**EL PASO COUNTY
 GRADING AND EROSION CONTROL PLAN CHECKLIST**

GALLOWAY
 RESPONSE

EPC Project Number: VR239

CUT & FILL MAP

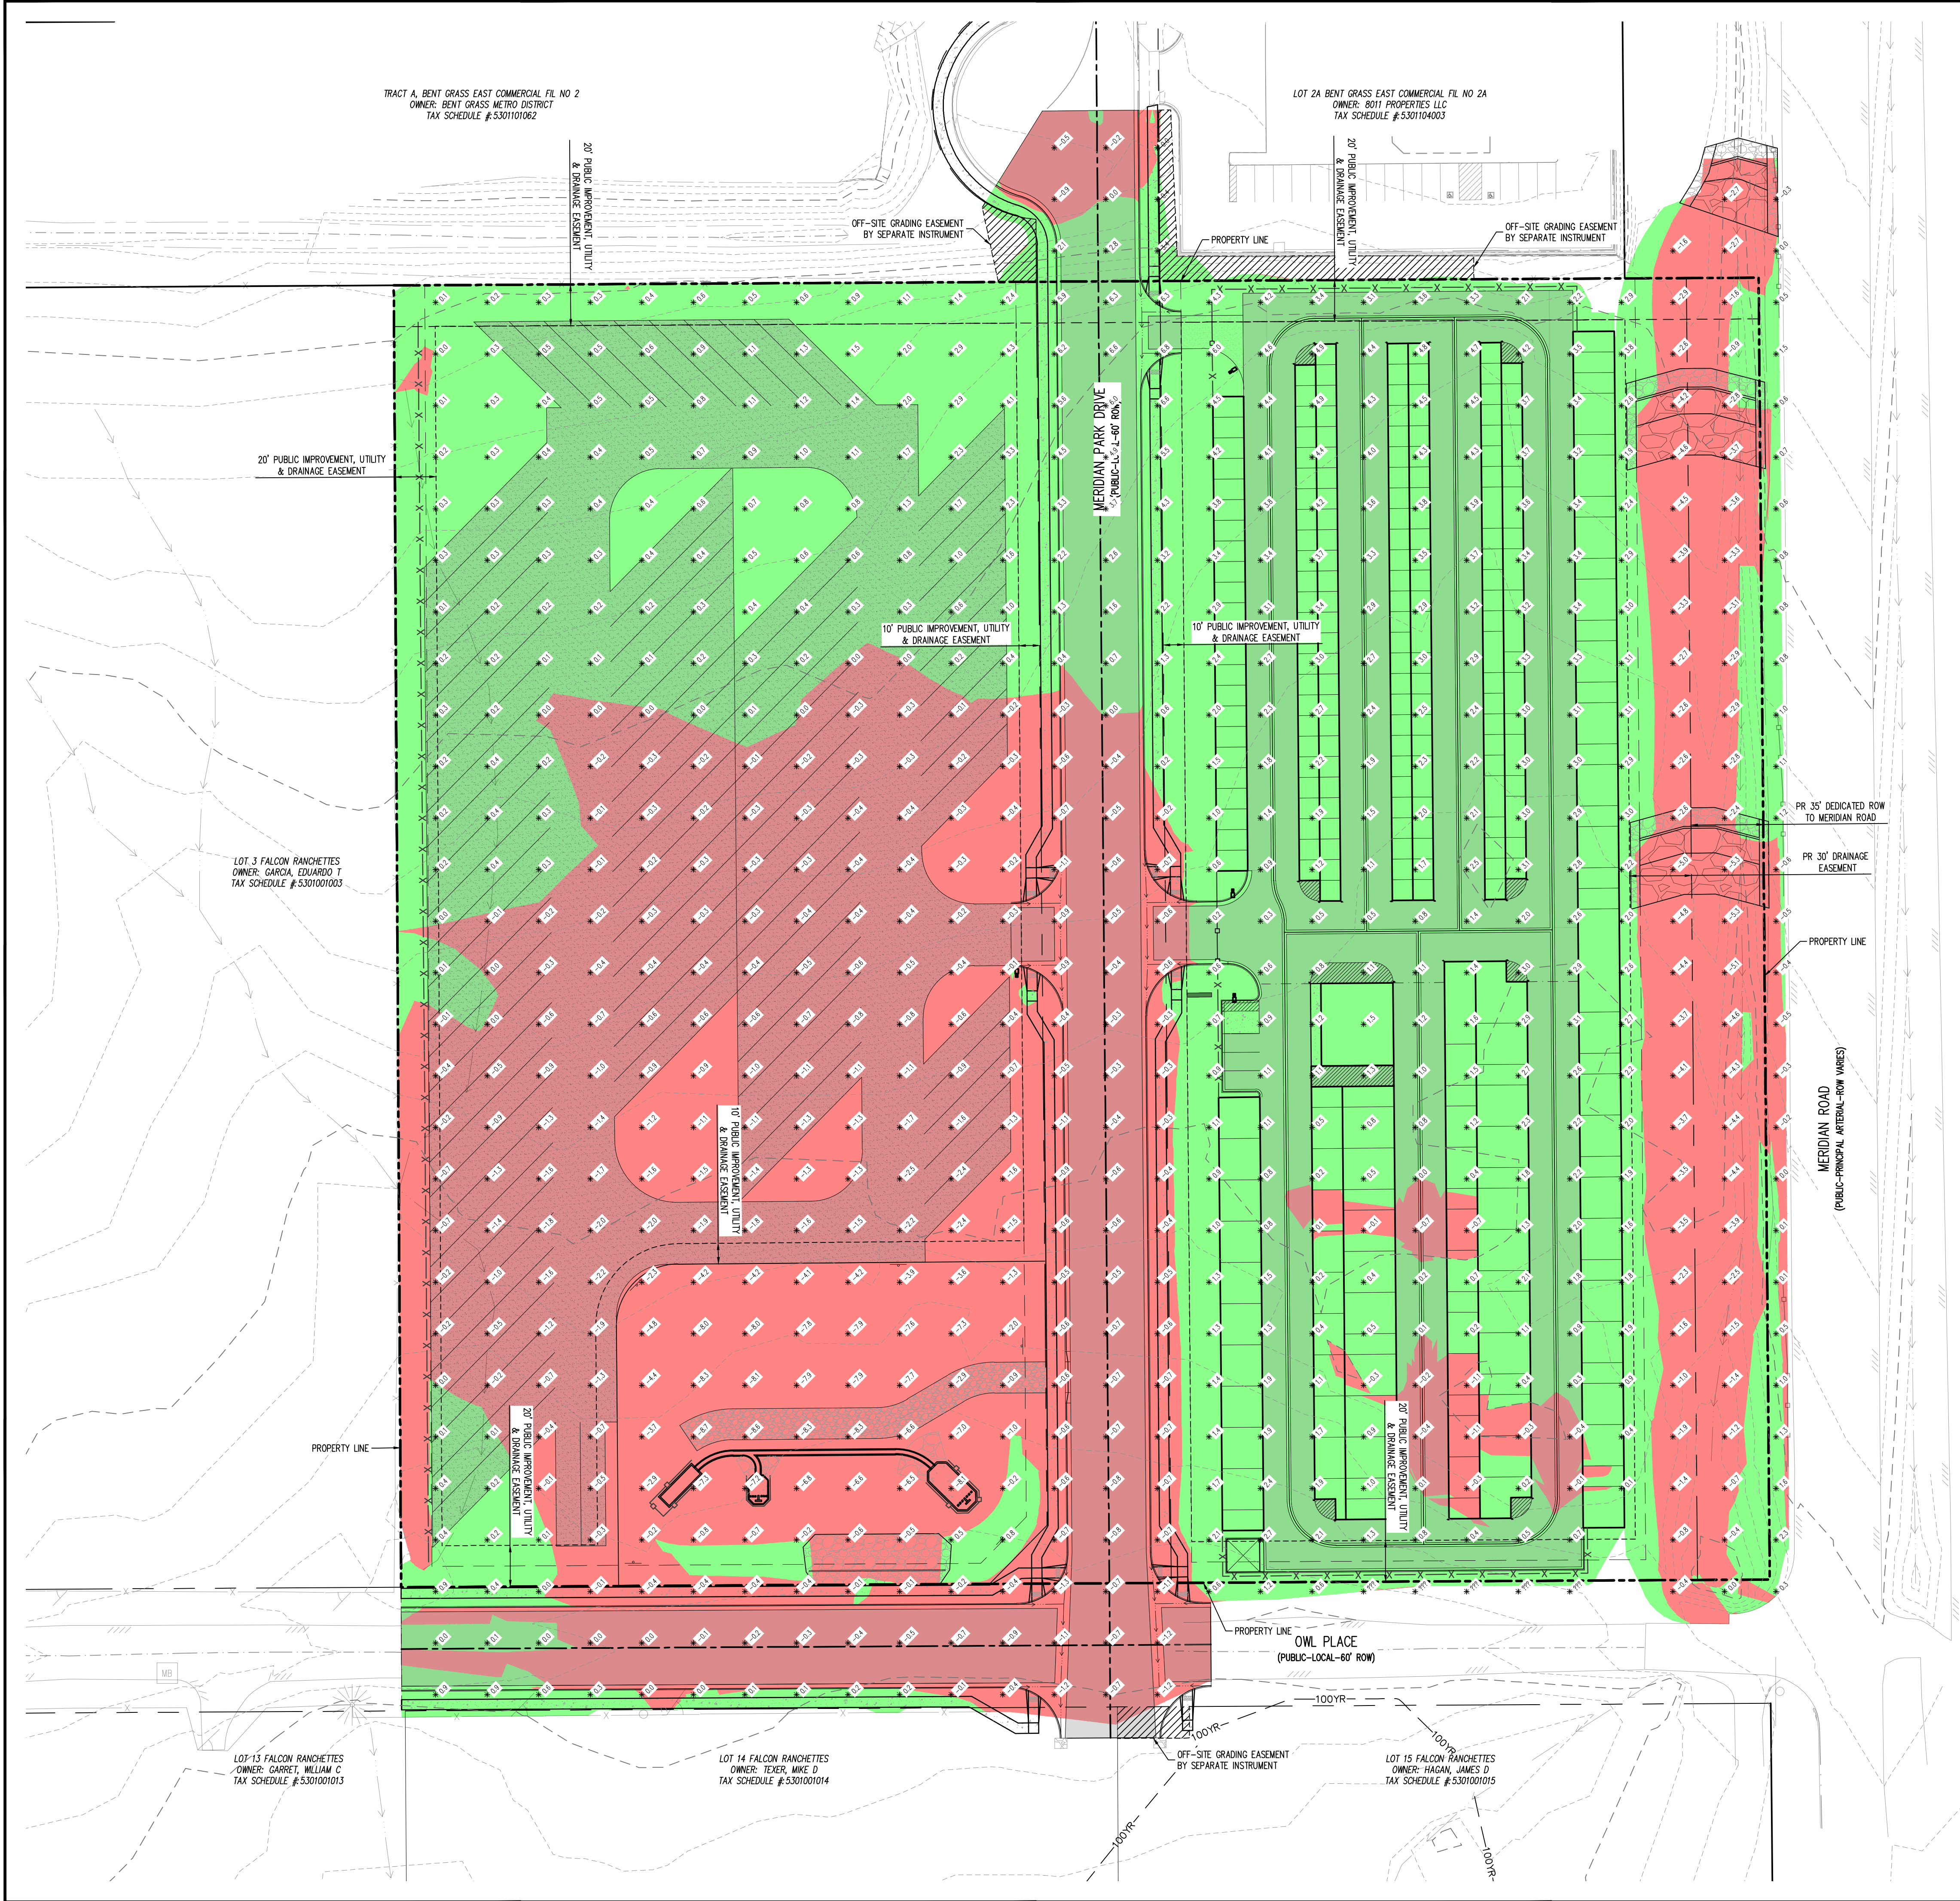
ADDED
 CLEAR
 OFFSITE
 GRADING
 LABELS TO
 CUT AND
 FILL MAP
